SSD 6010 - One Residential Building (Student Accommodation) within Darling Drive Plot

Submission by:

Qing Crugnale and Peter Crugnale

30 July 2013

SHADOW DIAGRAMS: PERSPECTIVE, SHOWING THE PEAK, WINTER SOLSTICE

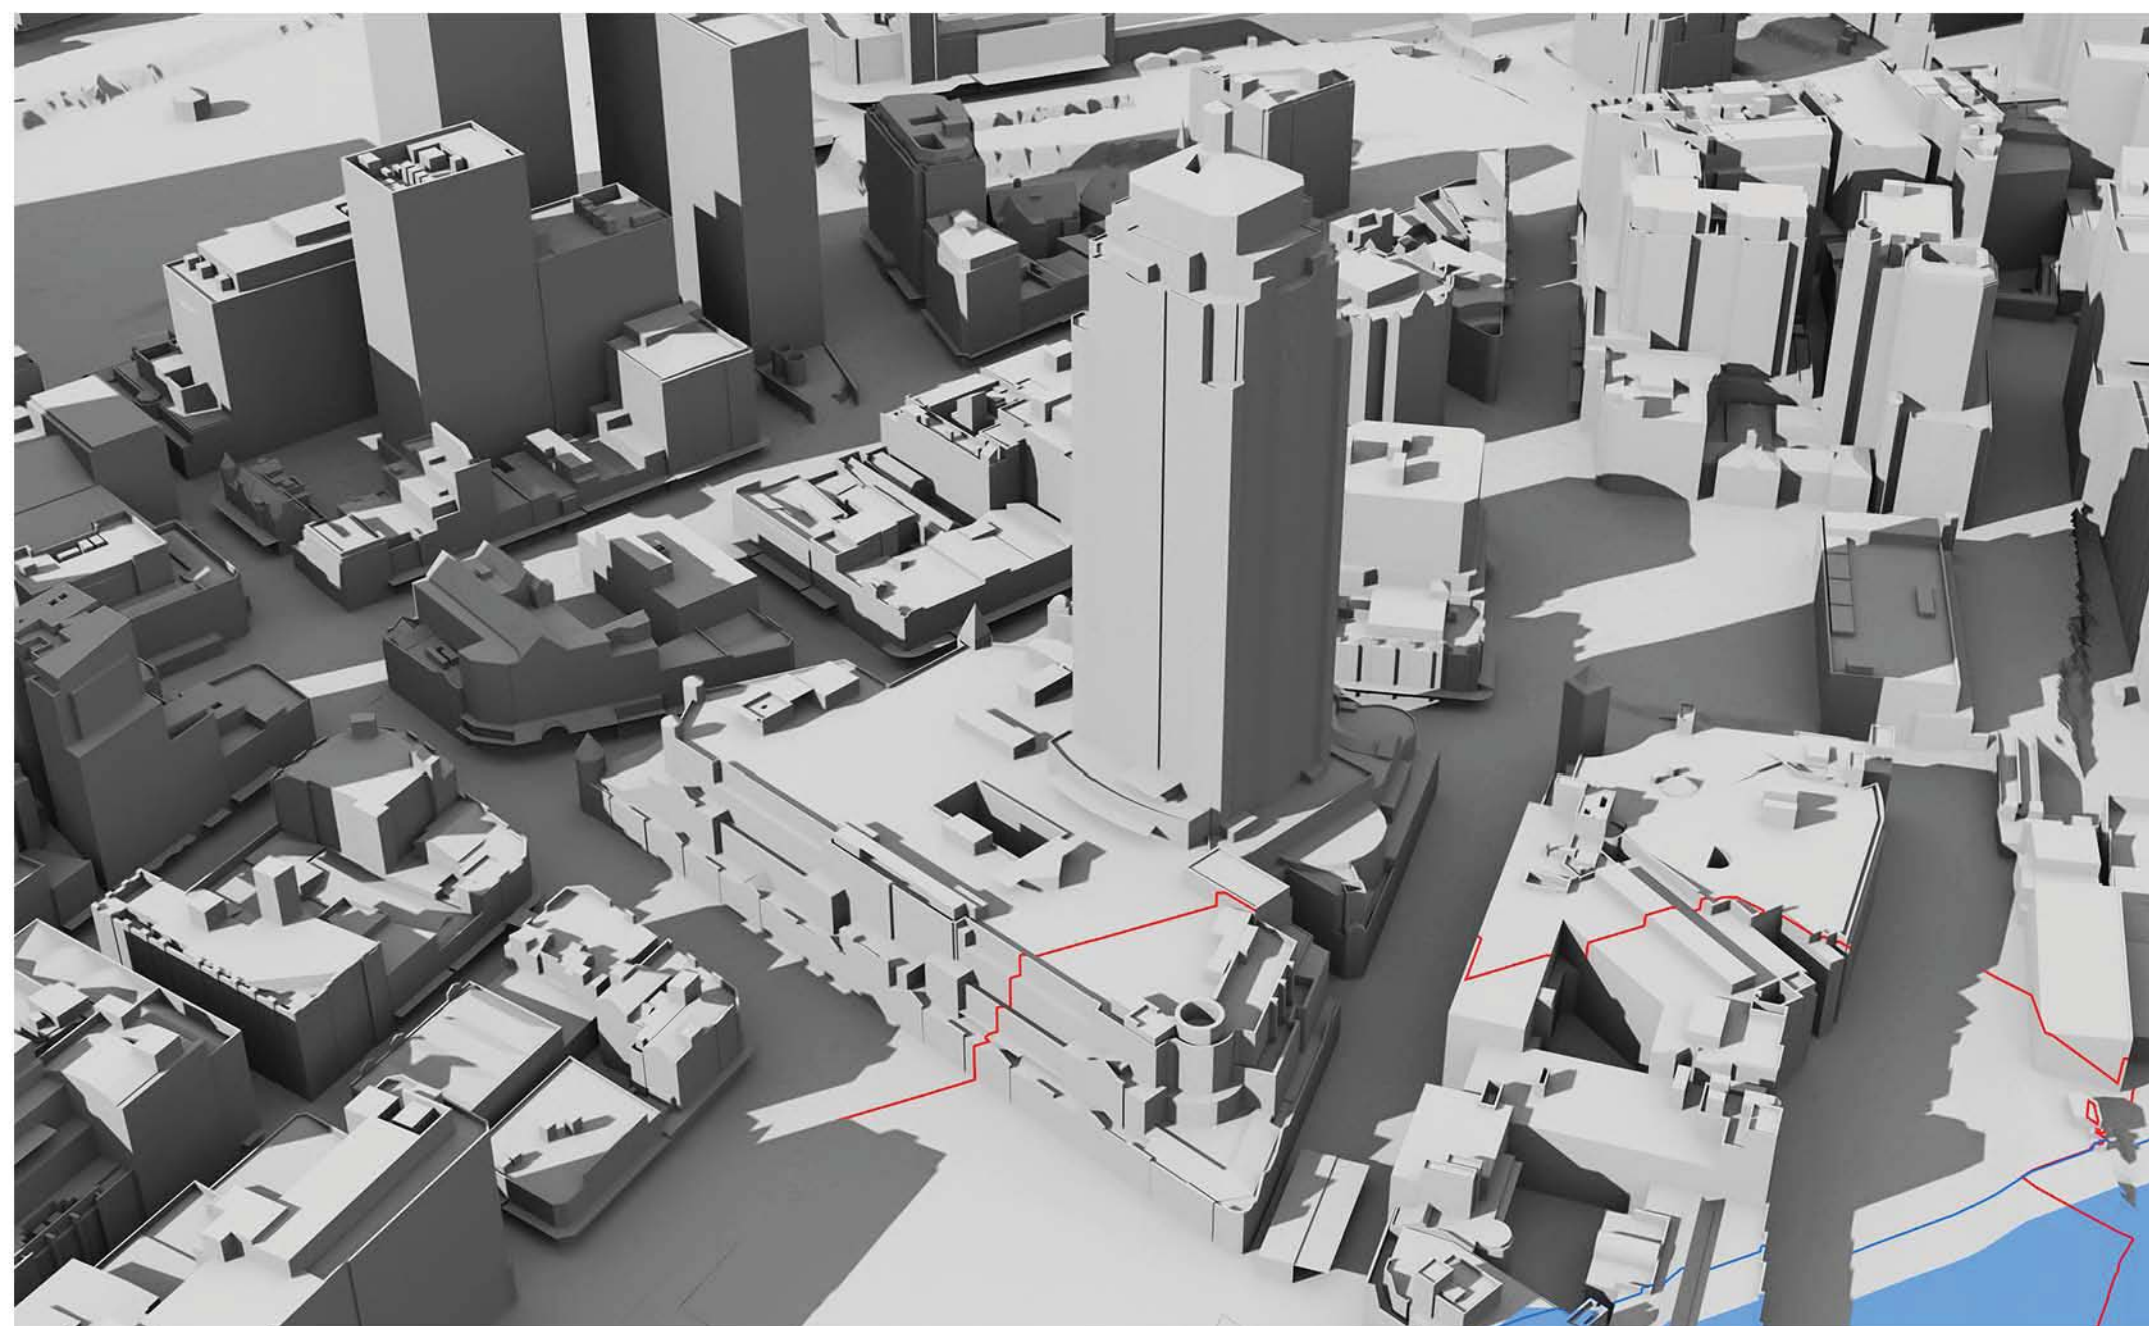
At 9am, 10am and 11am the west façade is totally in shadow due to other parts of The Peak building itself.

At 12pm there is still substantial existing shadowing on the west façade caused by the irregular shape of the west facade.

At 1pm the existing shadowing has been substantially removed, but not totally removed.

It can be concluded that some single aspect apartments on the west façade and some south-west dual aspect corner apartments currently receive less than 2 hours direct sunlight to habitable rooms and 50% of the private open space between 9am and 3pm on 21 June.

At 9am, 10am and 11am the west façade is totally in shadow due to other parts of The Peak building itself.

At 12pm there is still substantial existing shadowing on the west façade caused by the irregular shape of the west facade.

At 1pm the existing shadowing has been substantially, although not entirely, removed. However, overshadowing of lower levels of the west façade by the concept proposal parameter plan shadows for the N,NE and SE plots has already started.

By 2pm the existing shadowing has been totally removed. However, overshadowing of the west façade by the SSDA4 and SSDA5 buildings has appeared and risen further up the west façade than the concept proposal parameter plan shadows for the N,NE and SE plots, which is still present.

At 3pm, the proponent states correctly that 45-45% of the western façade is overshadowed by the SSDA4 and SSDA5 buildings.

It can be concluded that, as a result of combination of the proposed development with existing shadowing of the west façade, some single aspect apartments on the west façade and the south-west dual aspect corner apartments which currently receive less than 2 hours direct sunlight to habitable rooms and 50% of the private open space between 9am and 3pm on 21 June will suffer additional overshadowing. It is beyond our skills to count the number of such apartments. We note that the proponent has made no attempt to do so.
